KIRKLEES METROPOLITAN COUNCIL INVESTMENT & REGENERATION SERVICE

Reference No:	2024/70/90829/W
Site Address:	30, Wadsworth Fold, Lindley, Huddersfield, HD3 3NB
Description:	Variation of condition 2 (plans) on previous permission 2023/91419 for raising of roof and insertion of dormers to form 2nd floor bedroom
Recommending Officer:	Laura Yeadon

DECISION – CONDITIONAL FULL PERMISSION

Officer Report

client	MR A PHILLIPS		
project	30 WADSWORTH FOLD LINDLEY HUDDERSFIELD HD3 3NB		
drawing	PROPOSED PLANS AND ELEVATIONS		
revision	notes	date	drawn
A	ROOF RAISED BY 150mm	11.23	PB
scale :	1:50 and 1:100 AT A1	04.23	PB
project no.	drawing no.	revision	
2262	02	A

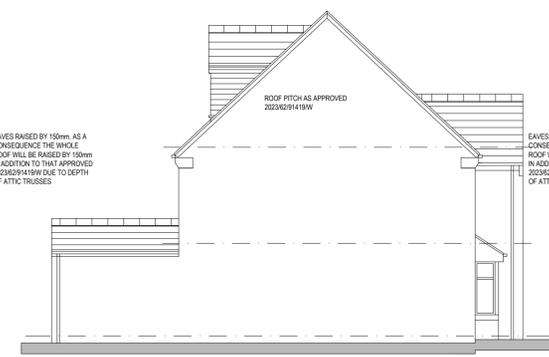
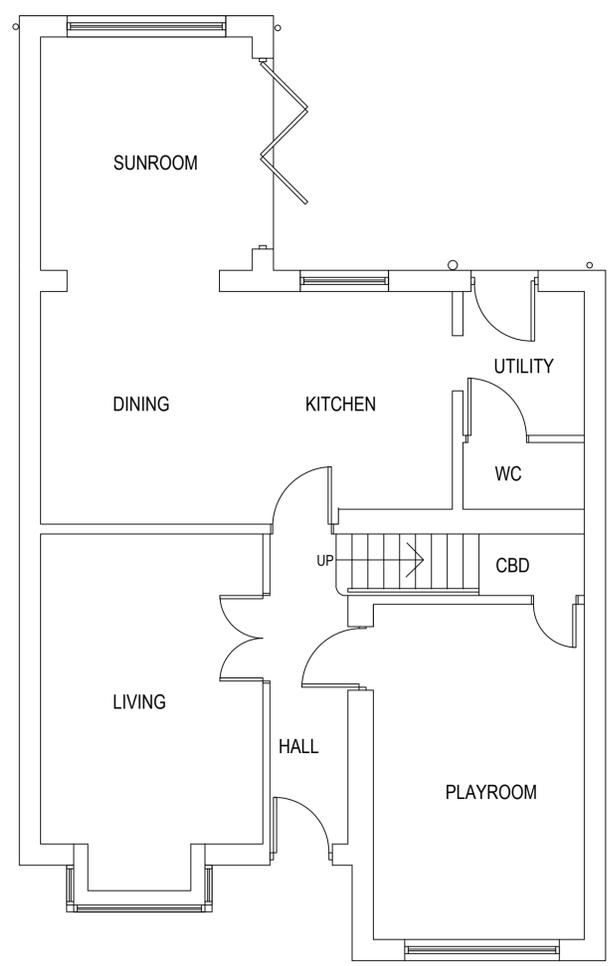
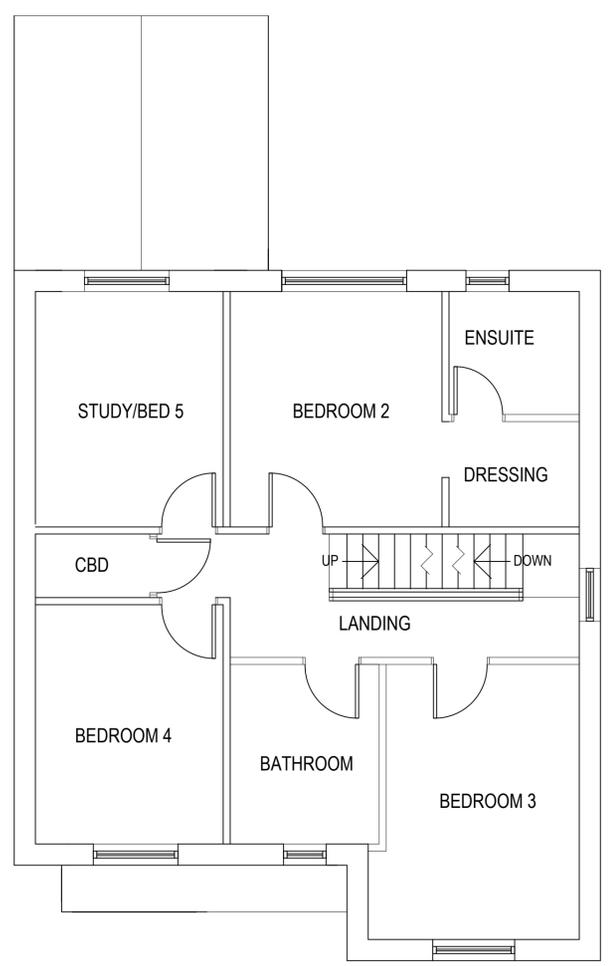
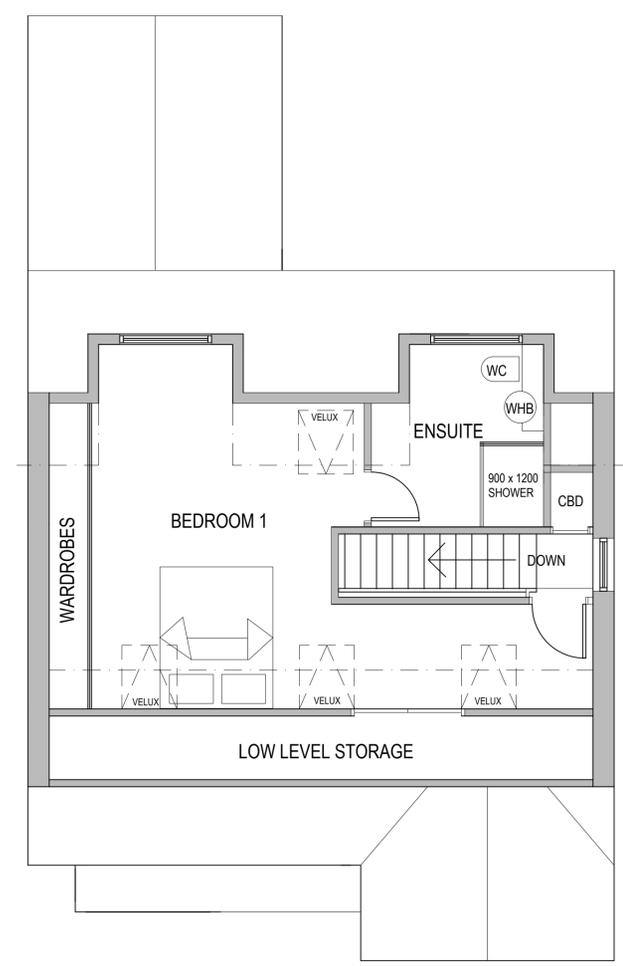
The application seeks permission under a Section 73 application to vary the approved plans. The proposal seeks to raise the eaves of the proposal by 150mm to accommodate the internal roof heights. As a consequence, the overall height of the building would be increased by 150mm over and above that previously approved.

This application seeks to raise the eaves of the property by 150mm which, as a consequence would increase the overall height of the property over and above the increased height as already approved.

Given the scope of the changes and the minimal height increase to the eaves of the property as a result of the proposed works, it is not considered that the increase in eaves height would result in a development that would be visually intrusive within the street scene whereby the properties are mainly detached and a similar design. The overall roof heights are staggered and the consideration of raising the ridge of the roof has already been assessed and considered acceptable as part of the previous application.

Due to the minimal, limited increase in the height of the eaves, it is not considered that the works would cause significant harm over and above the harm identified as part of the previous approval. Whilst the walls would be raised, it is not considered that this would cause undue harm from overlooking, overshadowing or by being overbearing.

It is also considered reasonable and necessary to add a condition to ensure that the additional course of stonework matches the existing, in the interests of visual amenity.

4. The walling material of the development hereby approved shall in all respects match those used in the construction of the existing building and be retained thereafter.
